Ribble Valley Borough Council
Church Walk,
Clitheroe,
BB7 2RA

Phone: 0300 123 6780
Email: lhscustomerservice@lancashire.gov.uk
Your ref:
Our ref: LHS/CS/3/2016/0301
Date: 15th April 2016

Proposal:	Erection of a new commercial building in connection with existing plant hire business.
Location:	Pendle Trading Estate Clitheroe Road Chatburn BB7 4JY
Grid Ref:	376376 - 443550

SITE PLAN 1:500

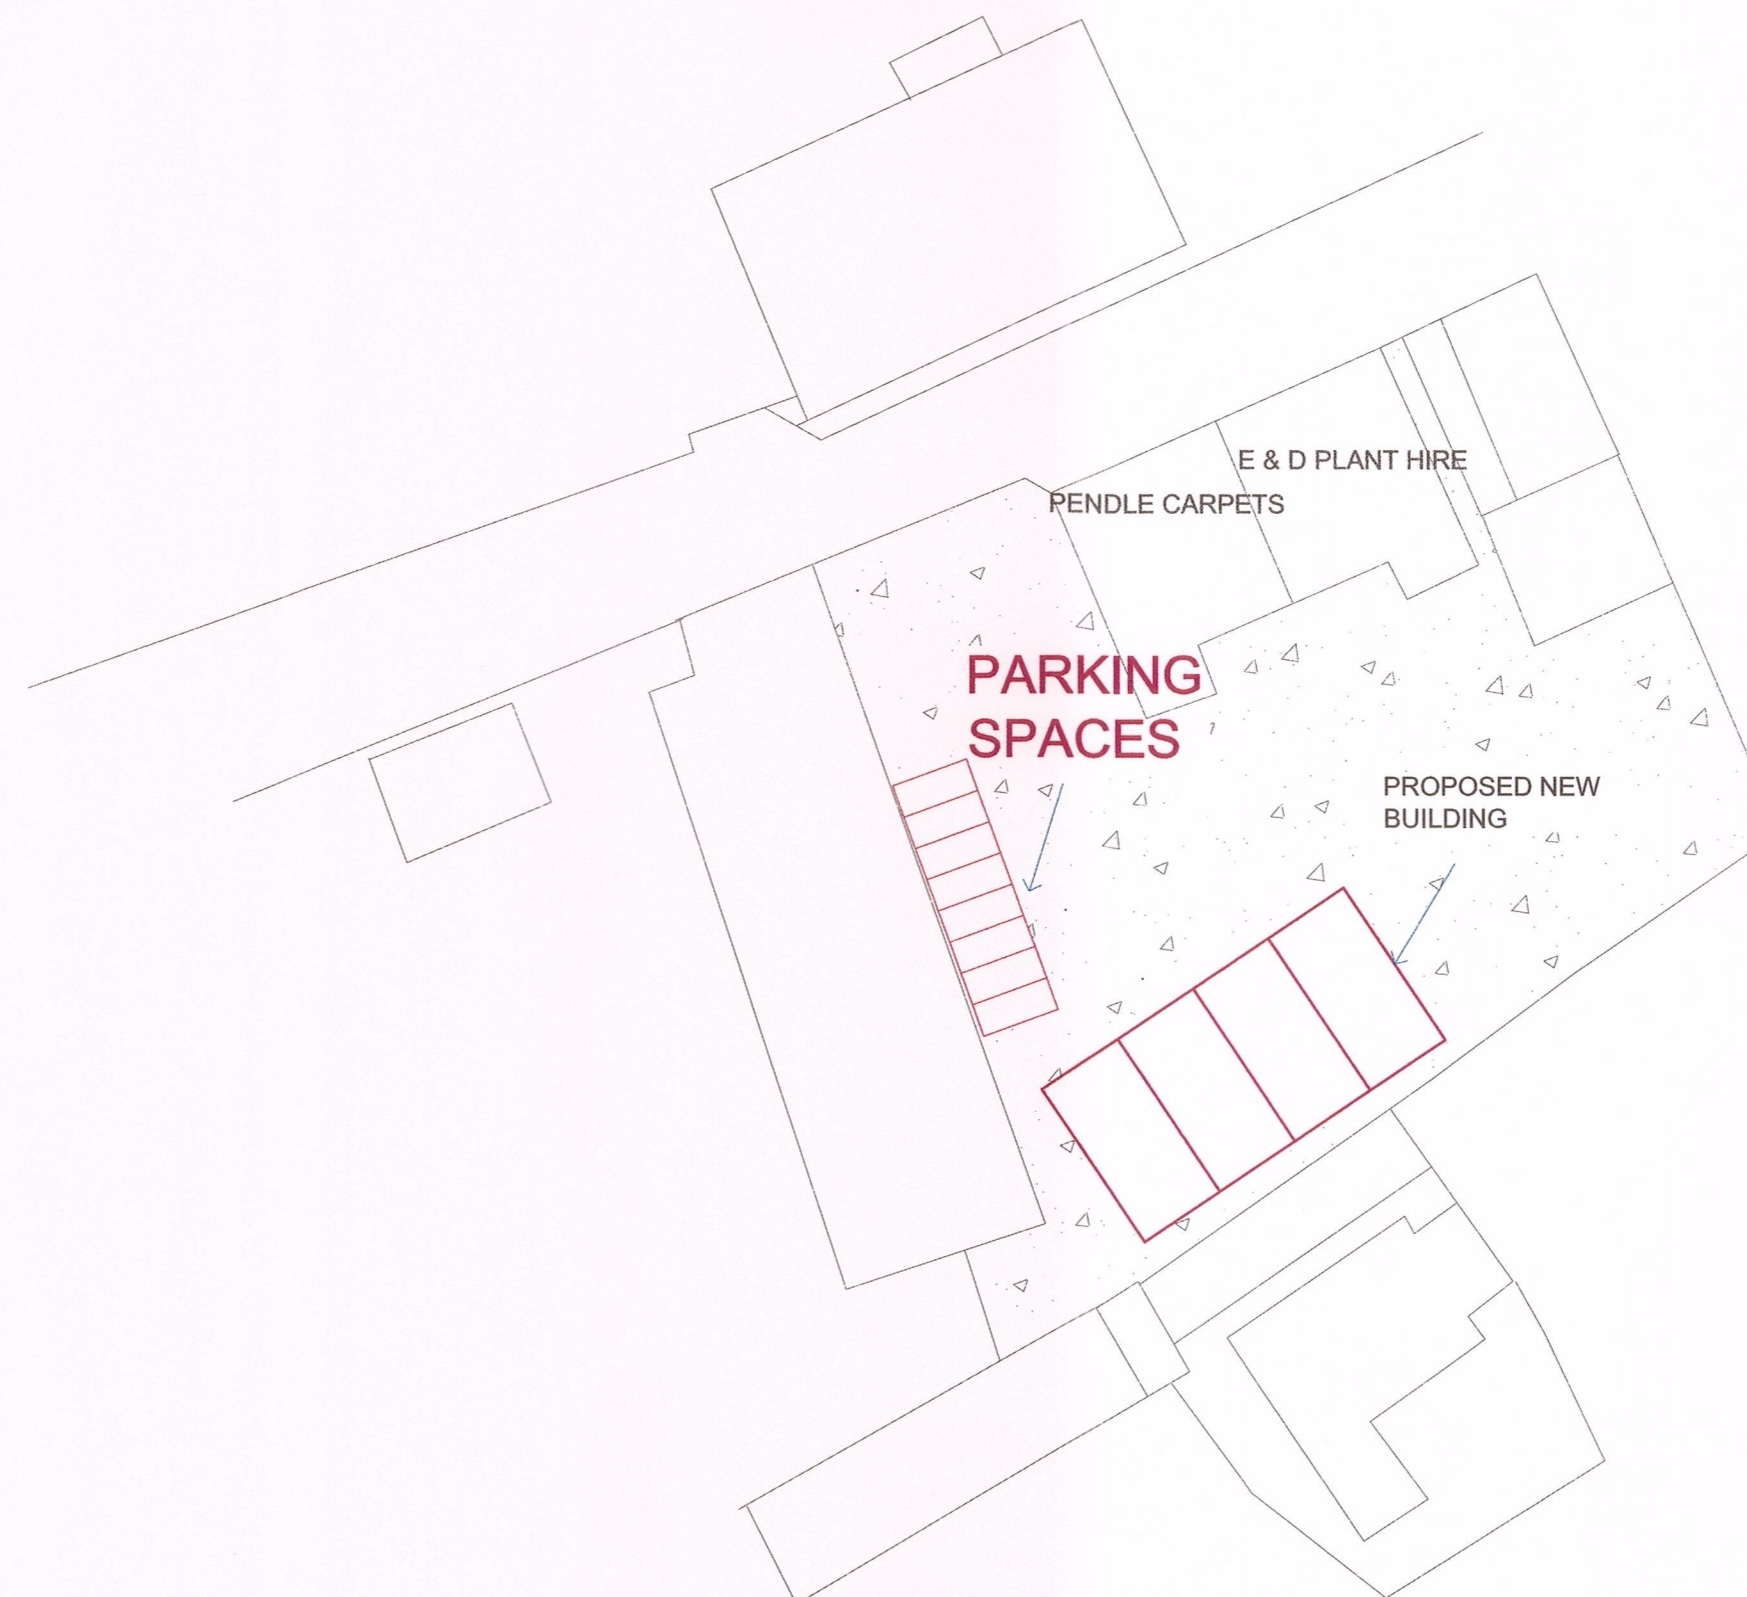
The Highway Development Control Section is of the opinion the applicant has not provided sufficient information to accurately assess the highway impact for the proposed new commercial units.

The applicant is advised to provide a car parking assessment for the existing units parking on the yard to determine if the overall development will have sufficient off-road car parking for the existing business use and the proposed new commercial units.

The car parking strategy to include the gross floor area for each permitted planning use for each business using the car parking area. The car parking provision is to be based on the car parking recommendations in the Joint Lancashire Structure Plan and the Ribble Valley Parking Standards. Accurate plans are then to be provided showing the car parking layout for the overall development with associated turning and manoeuvring areas. Consideration for the level of required mobility aided parking spaces
